INTER-OFFICE CORRESPONDENCE
AP 198 High Street-I

SUBJECT: Approval of permit for alterations to building at 198 High Street to provide a second means of egress from the third story thereof.

Subject: Permit for alterations
in second and third story of
lodging house at 198 High Street.

2nd floor Plan Scale 1/4" = 1'

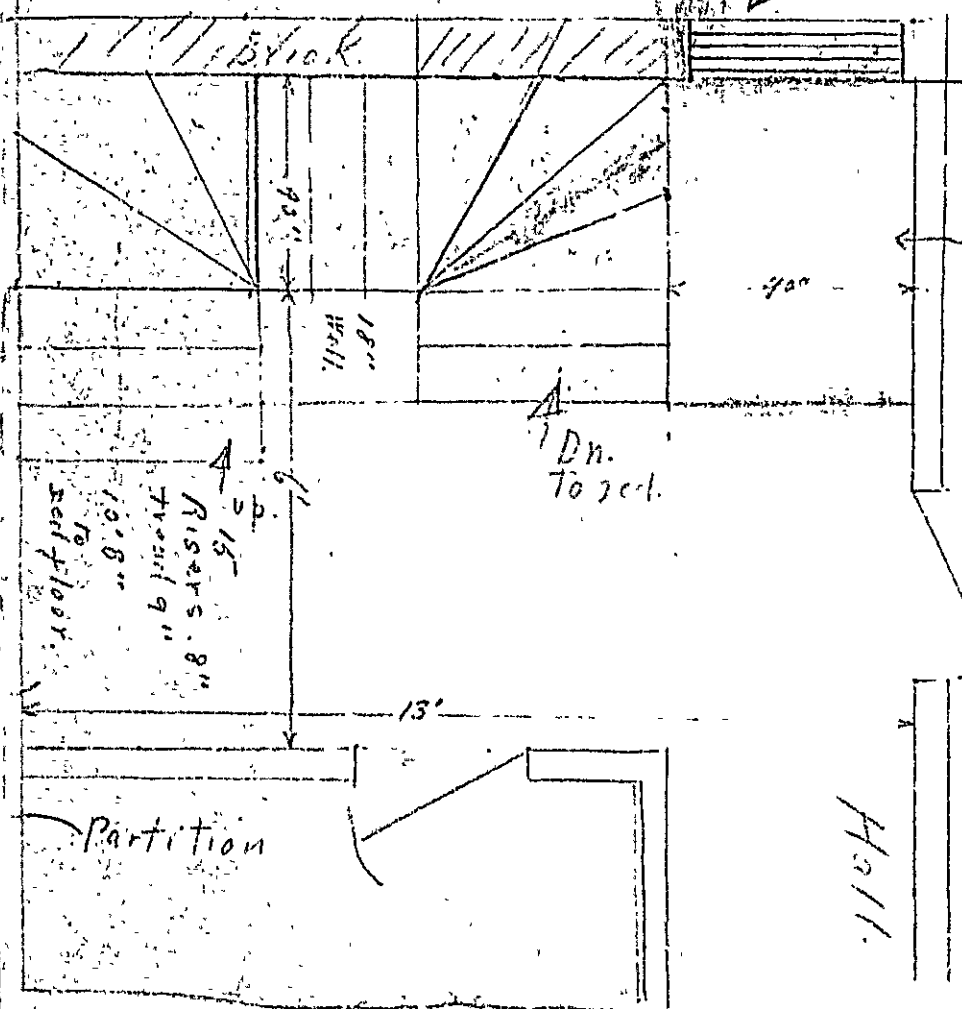
We would also like information as to whether a labelled fire door, a standard fire resistant door constructed as provided in Section 303-c-4 of the Building Code, or a solid wood door is required in the new opening in the brick wall between sections of the building and whether an angle iron frame or a wood frame metal covered is to be used if a fire door is required. Is this door to be made self-closing?

2. The Chief of the Fire Department, who has control of the unit situation in this existing lodging house, has specified that a fire door and frame shall be used in the new opening in the dividing partition in third story, but that it may be a standard fire-resistant door constructed as specified in Section 303c4 of the Building Code, instead of the Class "C" labeled fire door indicated on plans, if desired. He also specifies that the door shall be double hung so that it will swing in either direction and shall be provided with a device to keep it normally closed except when someone is passing through the opening. In case you have any question as to the construction of a standard fire-resistant door, such information may be obtained by inquiry at this office. We suggest that you determine from the Fire Chief whether a wood frame metal covered is to be provided for this door or whether a structural metal frame such as is ordinarily required by the Building Code for a masonry wall will be necessary.

*Standard Fire Resistant door,
Double hung so it will swing
way + be closed normally*
